Current Zoning: N1-A (Neighborhood 1)
Proposed Zoning: R-8MF(CD) (Multifamily Residential, Conditional)

Approximately 14.46 located west of N Tryon Street, east of Morehead Road, and north of Floyd Smith Office Park Drive.

The petition proposes to develop a vacant parcel with 70 single family attached residential units and accessory uses.

STAFF RECOMMENDATION

SCHEMATIC SITE PLAN

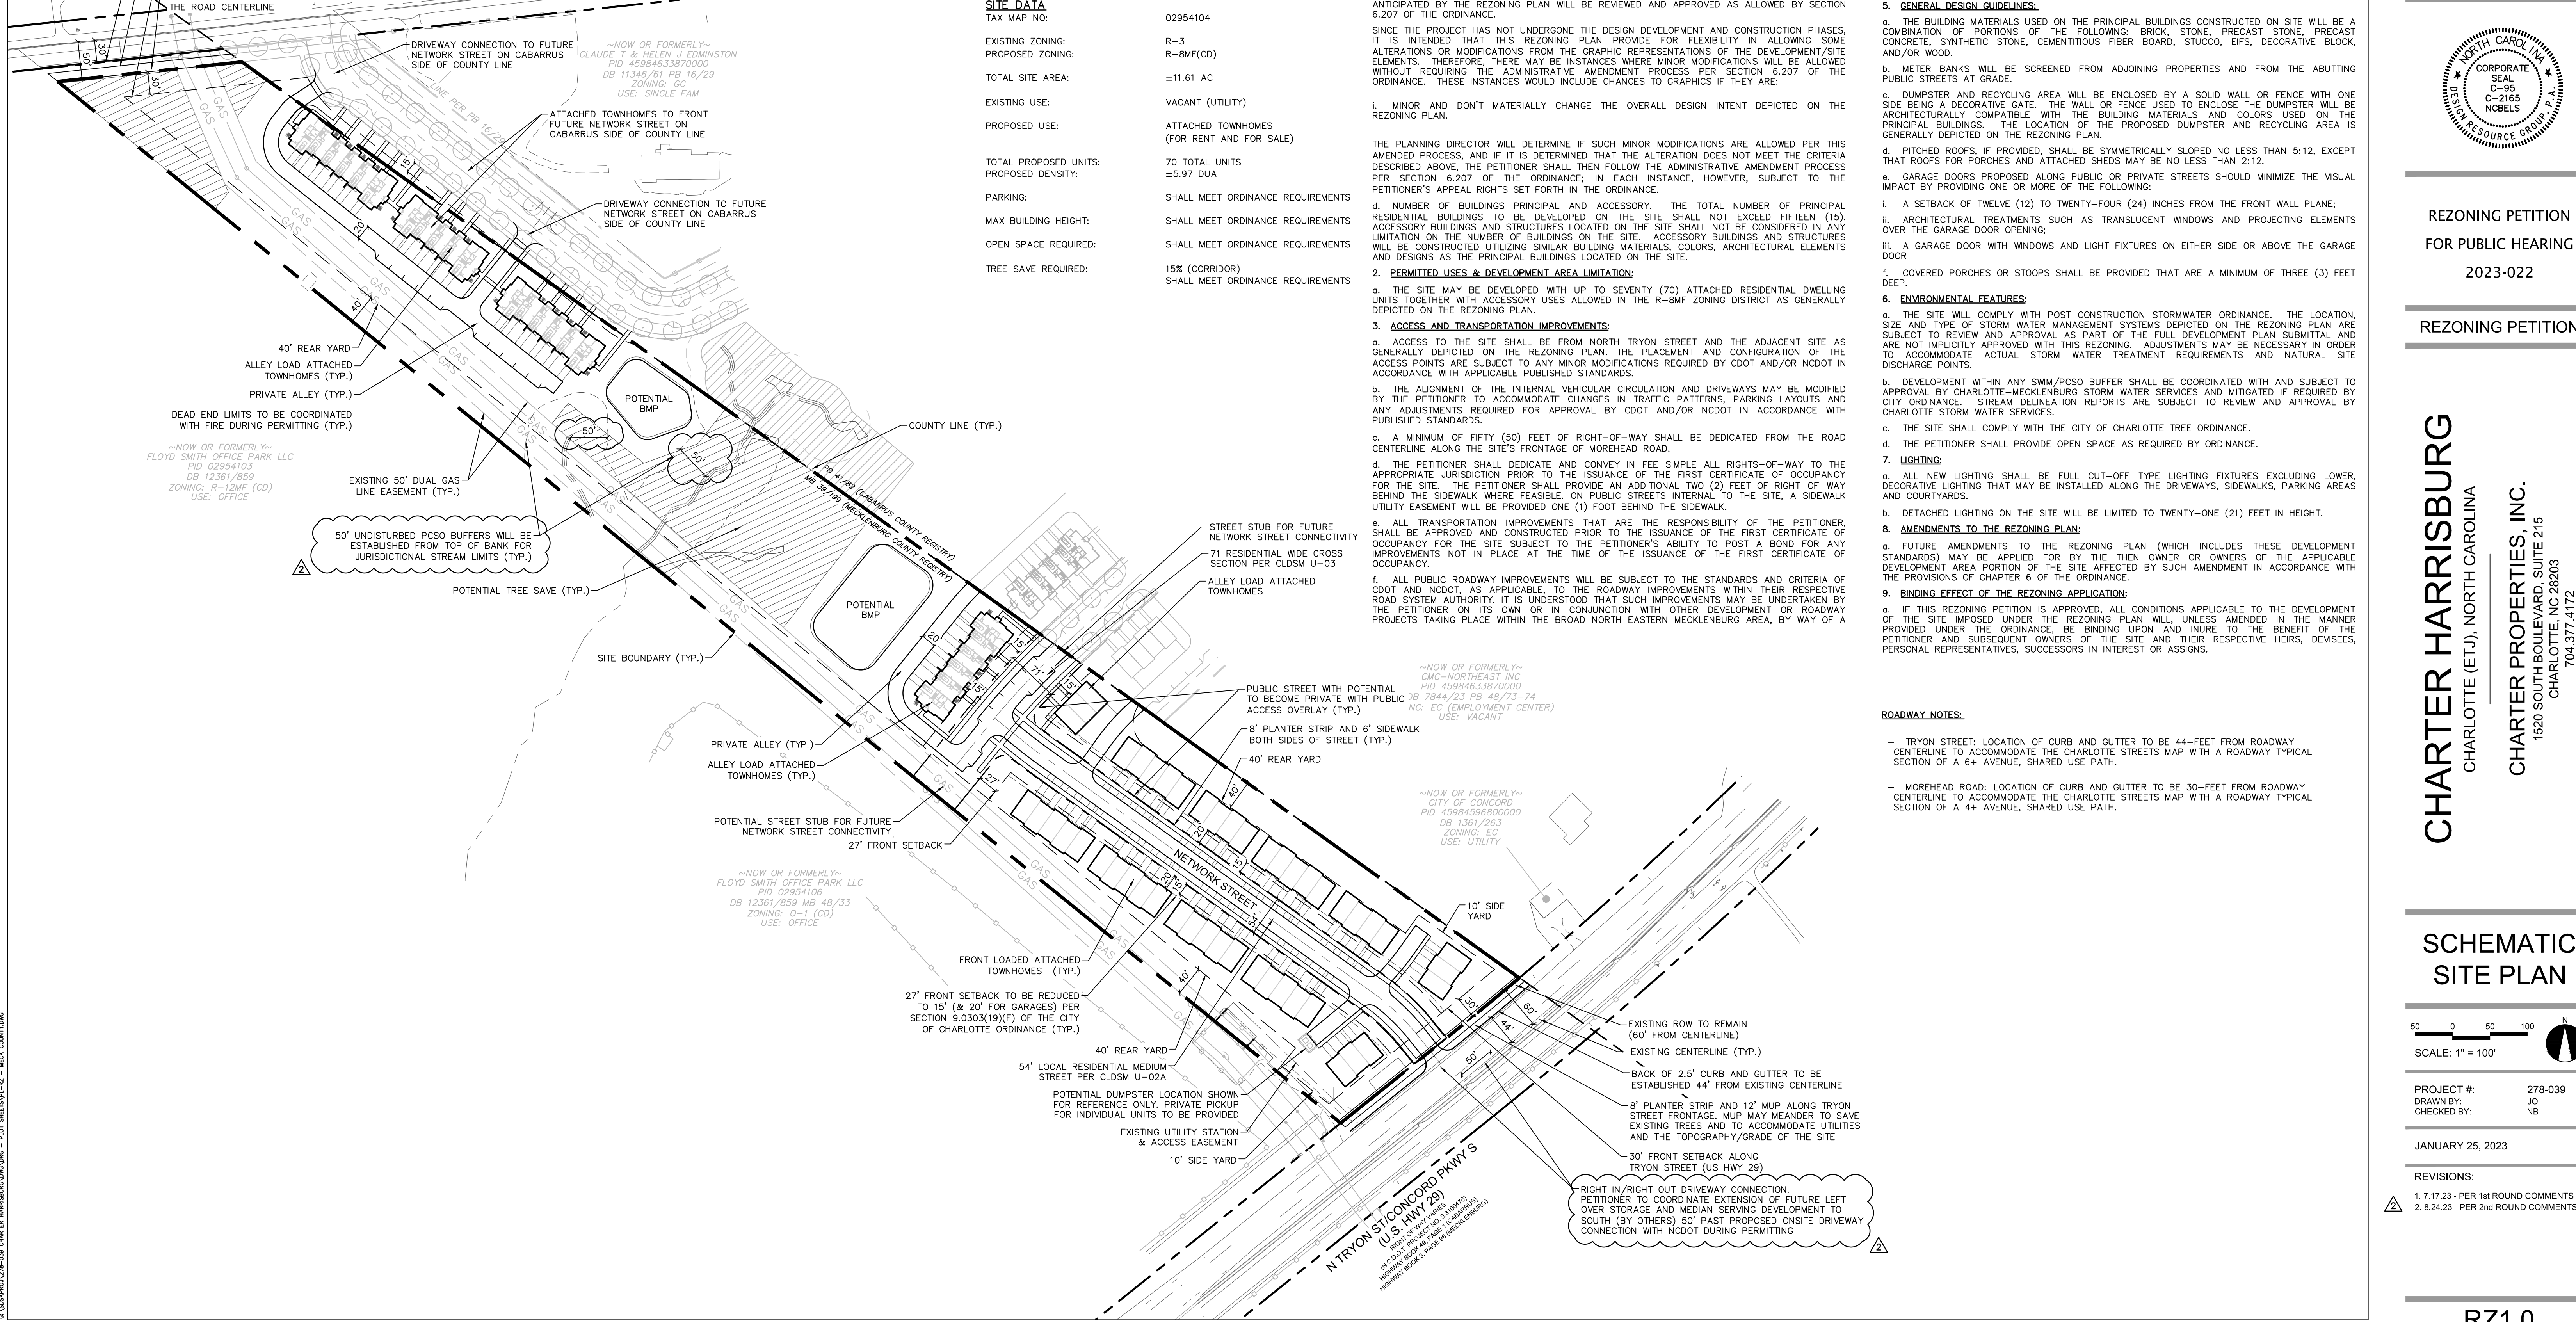
1. ~~Revise site plan and conditional notes to commit to removing the Tryon Street access point in coordination with NCDOT.~~ **ADDRESSED**

2. ~~Revise note regarding 50' undisturbed stream buffers to delete the second sentence stating "Final buffer limits will be based on confirmed jurisdictional limits after draining of pond and final impact limits that are pursued."~~ **ADDRESSED**
